Application Ref: 3/2022/1040  
Date Inspected: 07/10/22  
Officer: KH

#### DELEGATED ITEM FILE REPORT:

**Development Description:** Reconfiguration of internal layout of previously converted barn including insertion of new openings.  
**Site Address/Location:** Whitecroft Barn Whitecroft Lane Mellor BB2 7HA

› DRAWING TITLE
Proposed First Floor Plan

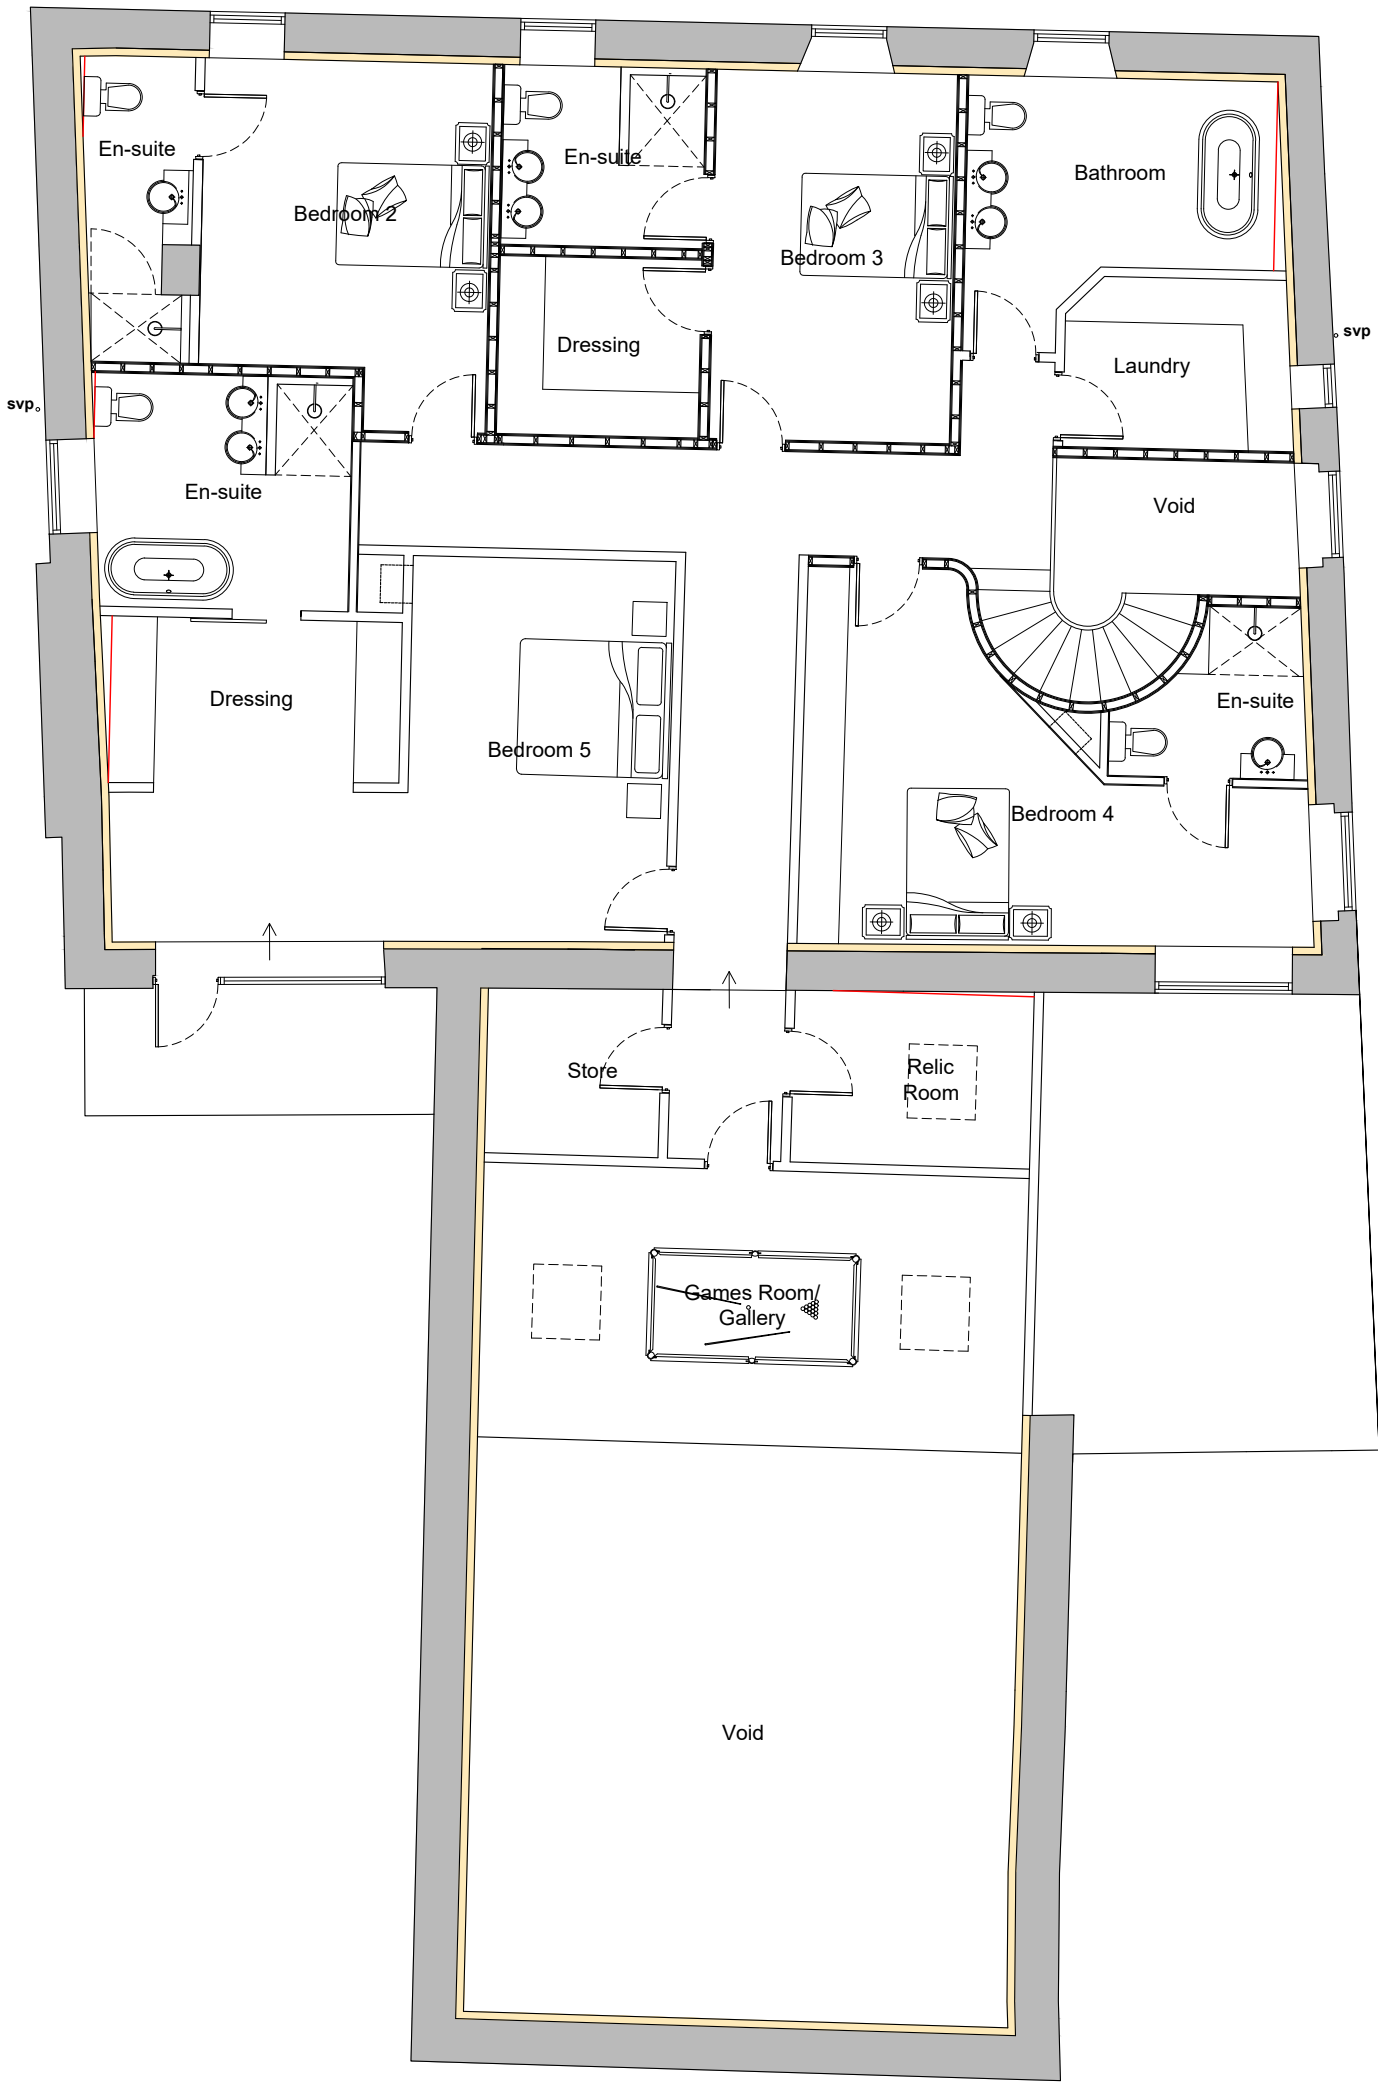
The existing workshop/store is sited to the south (rear) of the site. The adjacent residential properties, Whitecroft Farmhouse and 12 Whitecroft Lane to the west and east, would not be unduly affected by the proposed conversion and new windows. The properties to the north lie across the highway and would not be affected by these changes which are mainly to the rear (south) of the site. The insertion of new windows at ground floor level in the new ancillary accommodation would be screened by existing boundary treatments. The low profile rooflights providing light to the first floor gallery level would not result in any unacceptable overlooking issues.

Design of the replacement windows and new openings has been rationalised with the revised scheme designed to reflect those originally approved and the number and size of the openings limited in order to retain more of the original fabric. The existing concrete roof will be replaced with natural slate and this should be acceptable. Details of the materials can be controlled by an appropriate condition.

› DRAWING TITLE
Proposed Ground Floor Plan

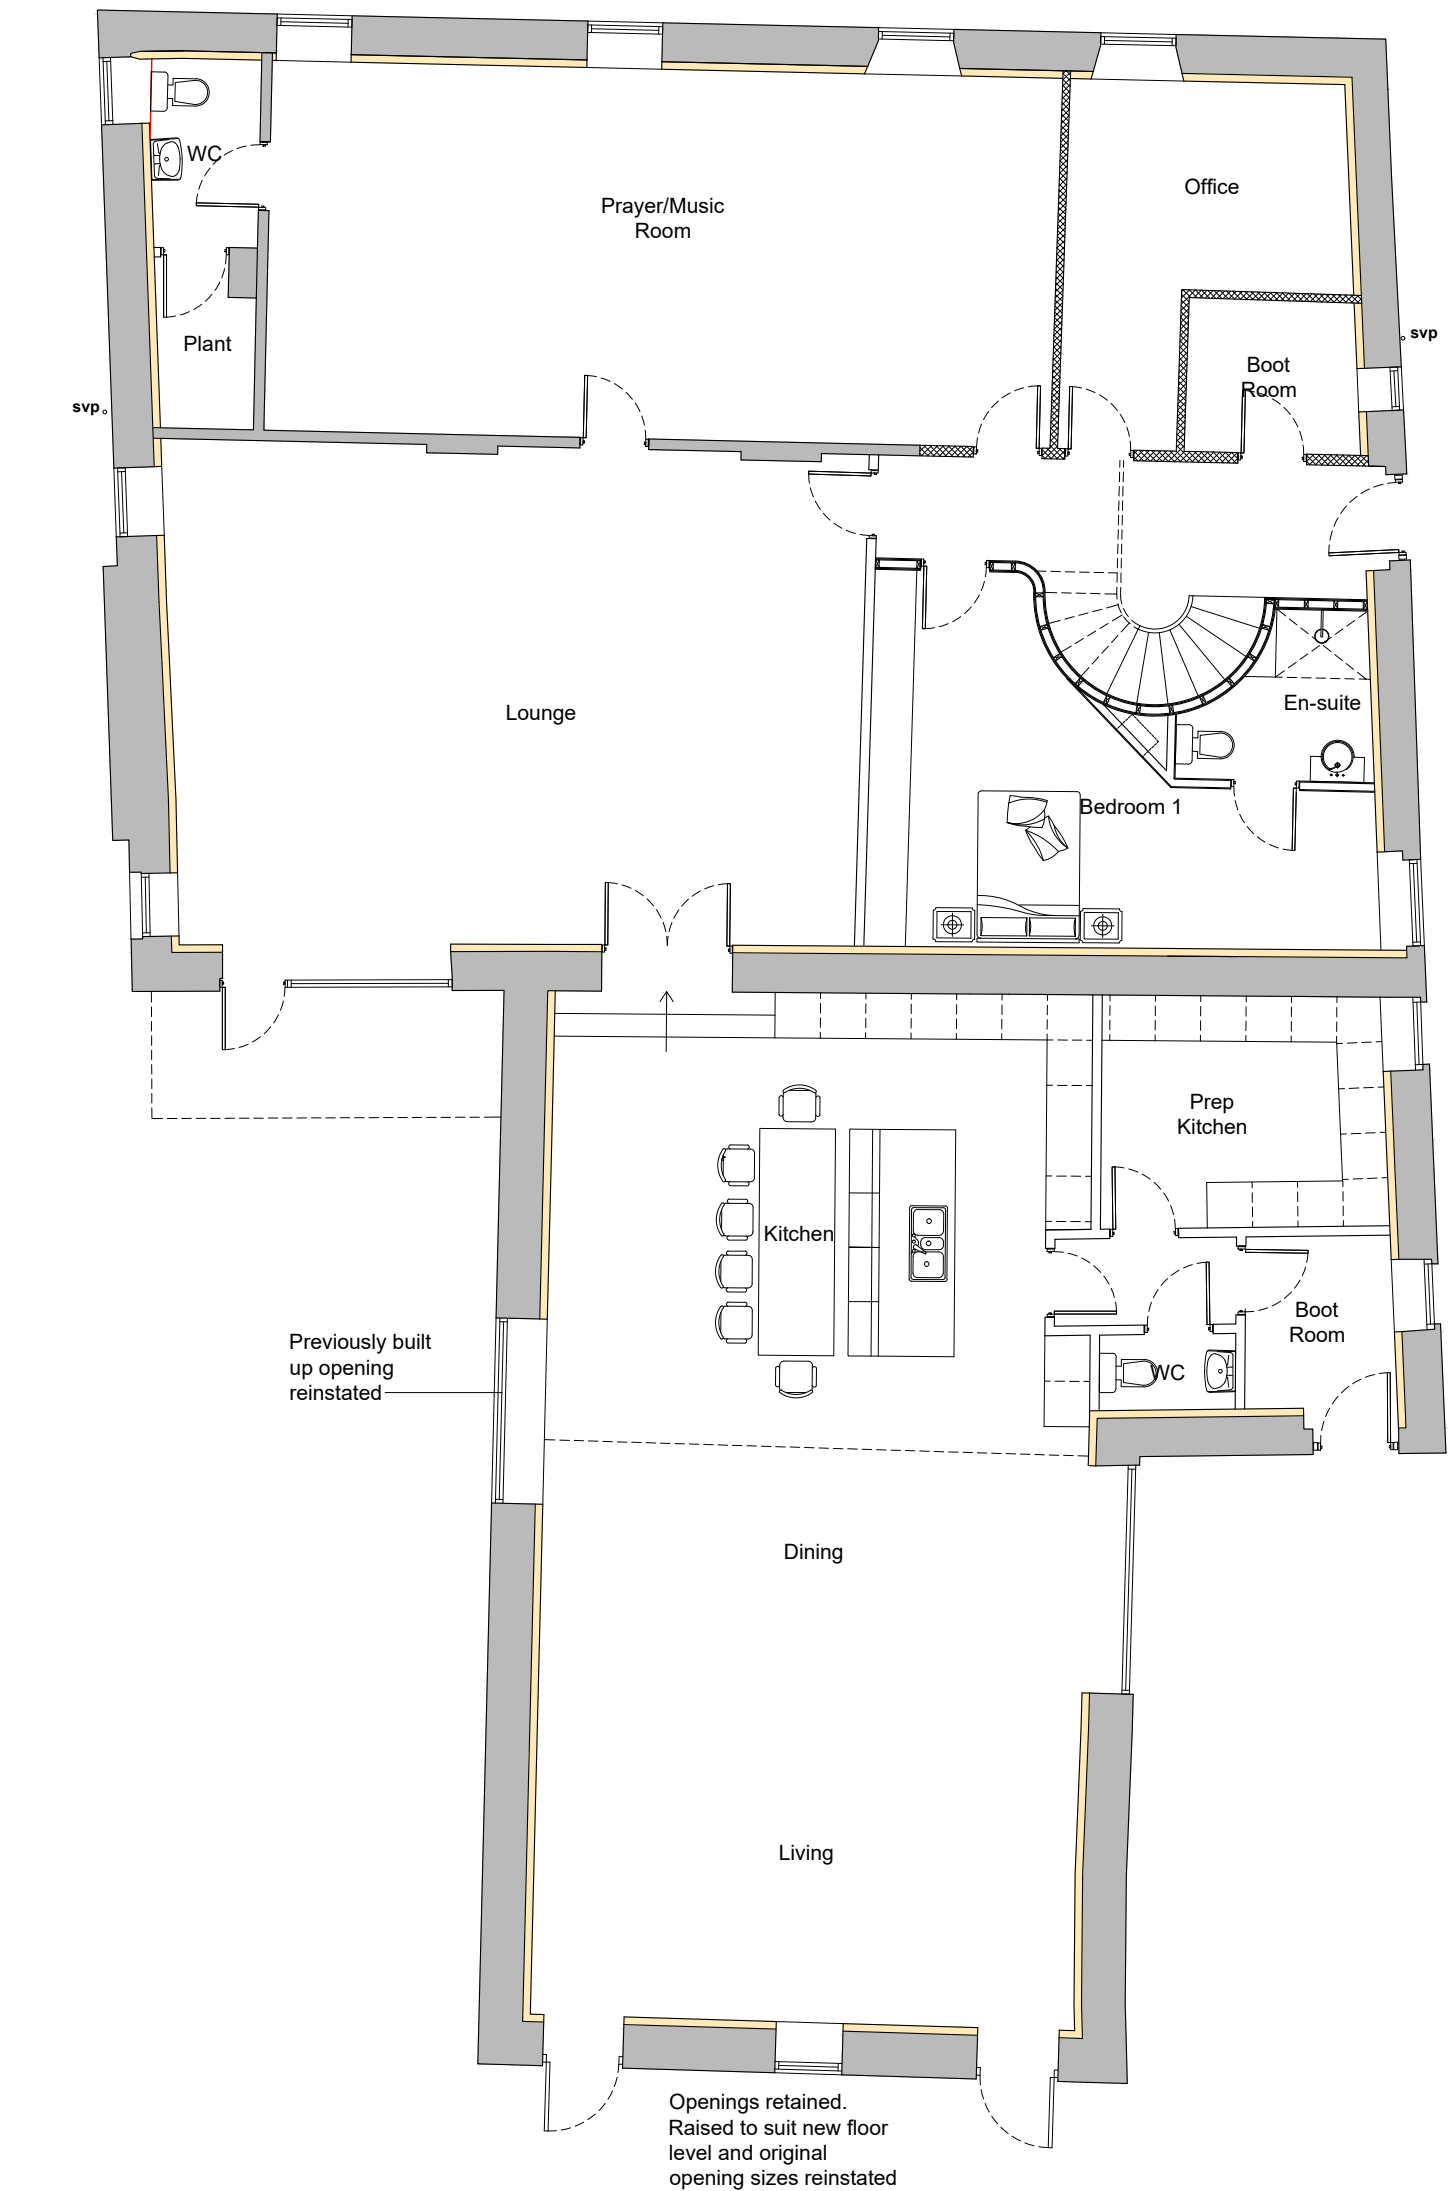
It is acknowledged that there are neighbour concerns about the floor plans indicating a prayer/music room within the existing property. Any internal changes within the barn conversion can be carried out without the need for planning permission where it would remain as residential and incidental to the enjoyment of the dwelling. There is nothing to suggest in the application that this would not be the case. Therefore any additional soundproofing or parking would not be reasonable to request. Any alternative (non-incidental) commercial or community use, would be a matter for planning enforcement to investigate and may require planning permission.

REVISION	DATE	DESCRIPTION
CLIENT		
Mr T Sarodia		
PROJECT		
Proposed Internal Alterations & Refurbishment of Whitecroft Barn		
DRAWING TITLE		
Proposed North & South Elevations		
SCALE	DATE	DRAWN
1:100@A3	Oct '22	PRH
DRG NO.		CHECKED
EAD_181_P_09

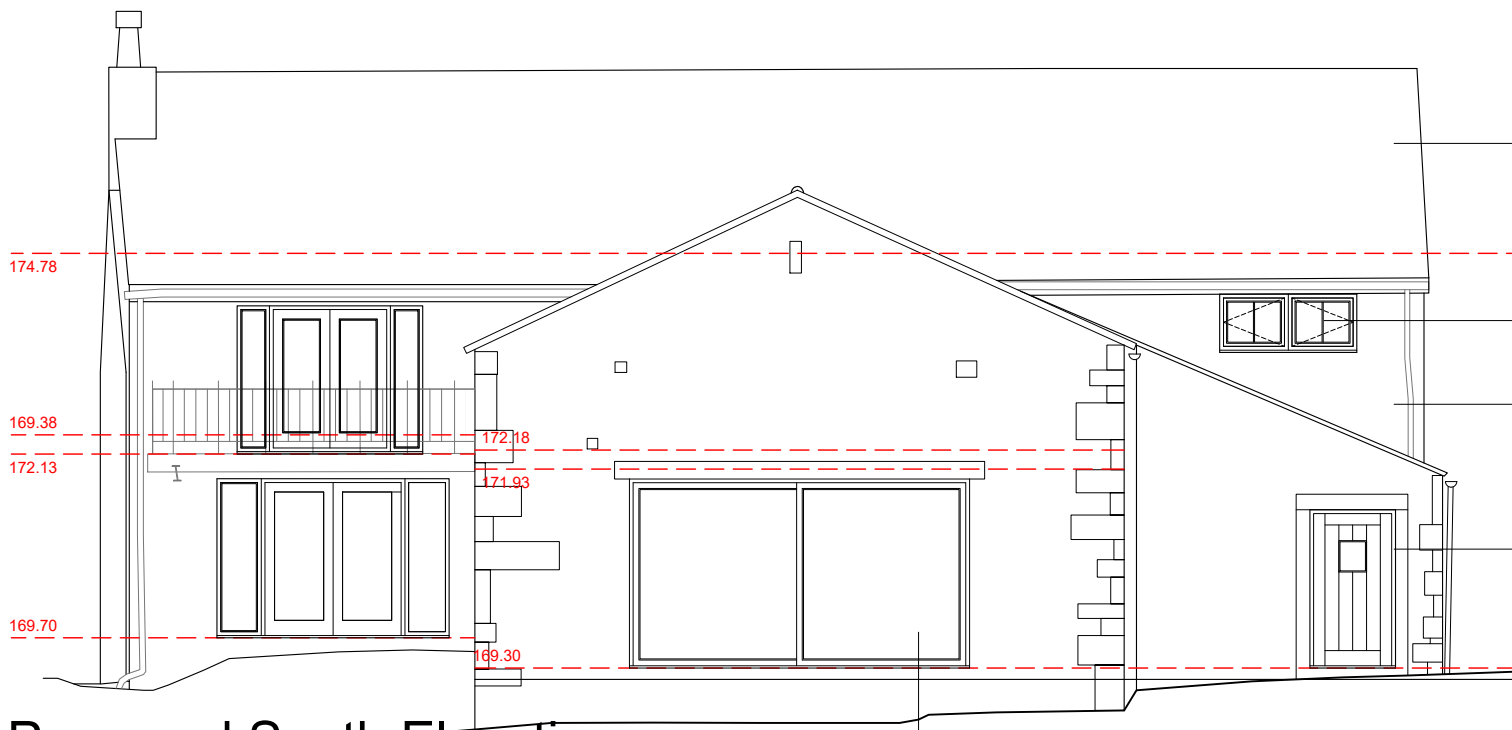
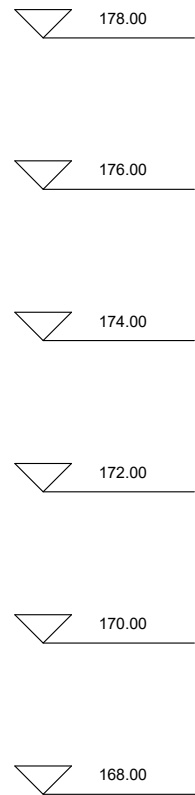
The external changes proposed include replacement windows and changing doors to windows. The use of the workshop/store as residential accommodation would not result in any harm visually and no increase in the volume of the building is proposed that would result in any additional impact on the openness of the Green Belt. The external changes are small scale with the number of rooflights being reduced and the replacement windows will be aluminium.
